RICHMOND AMERICAN HOMES JOB#26160023

PLOT PLAN LOT 1

DISAPPROVED
Plan Review
03/26/2019 3:37:44 PM
Kdyounger
EPC Planning & Community
Development Department

ADDRESS: 7044 BOREAL DRIVE

PLOT PLAN LOT 1

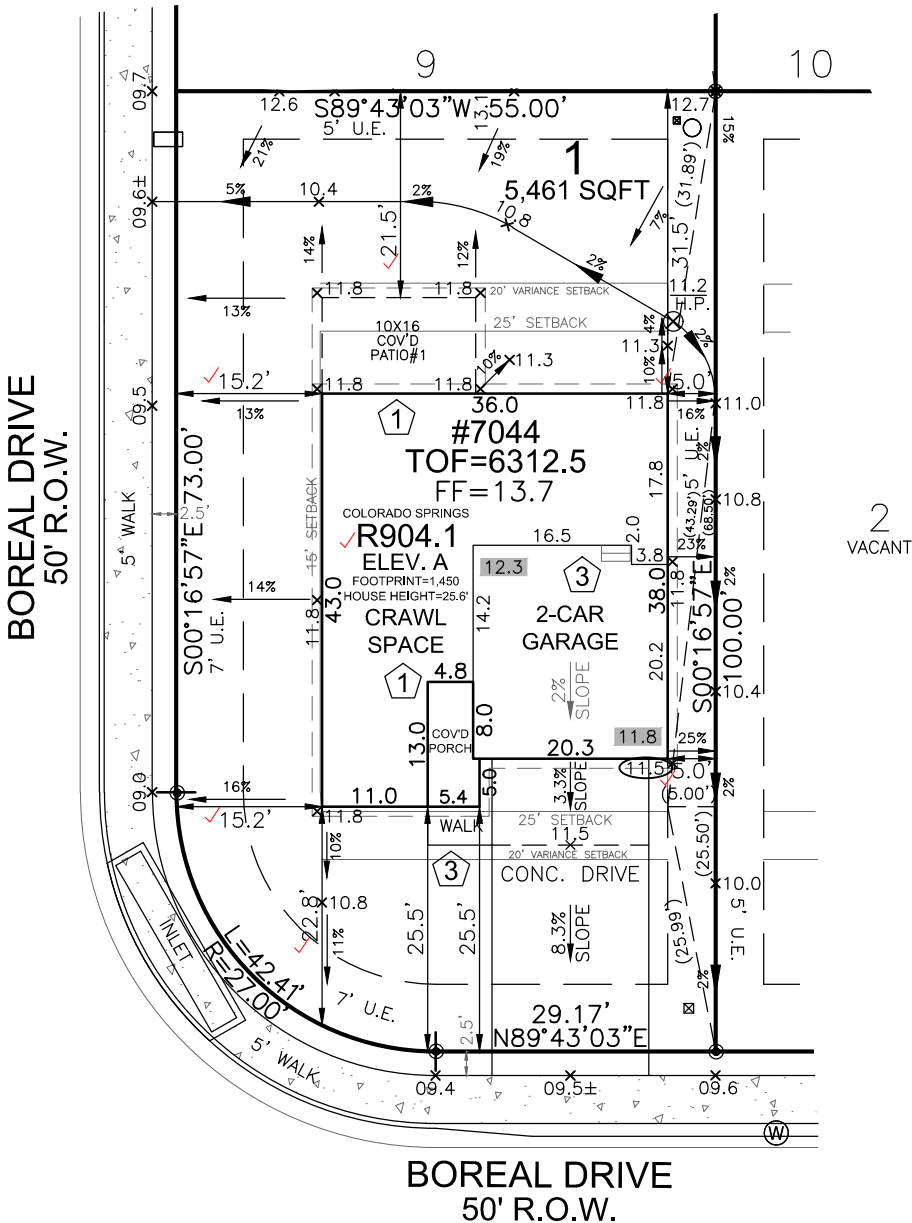
FRONT SETBACK REQUIRES 25'

REAR SETBACK REQUIRES 25'

MUST OBTAIN EASEMENT HOLDER APPROVAL FOR ROOF EAVE ENCROACHMENT
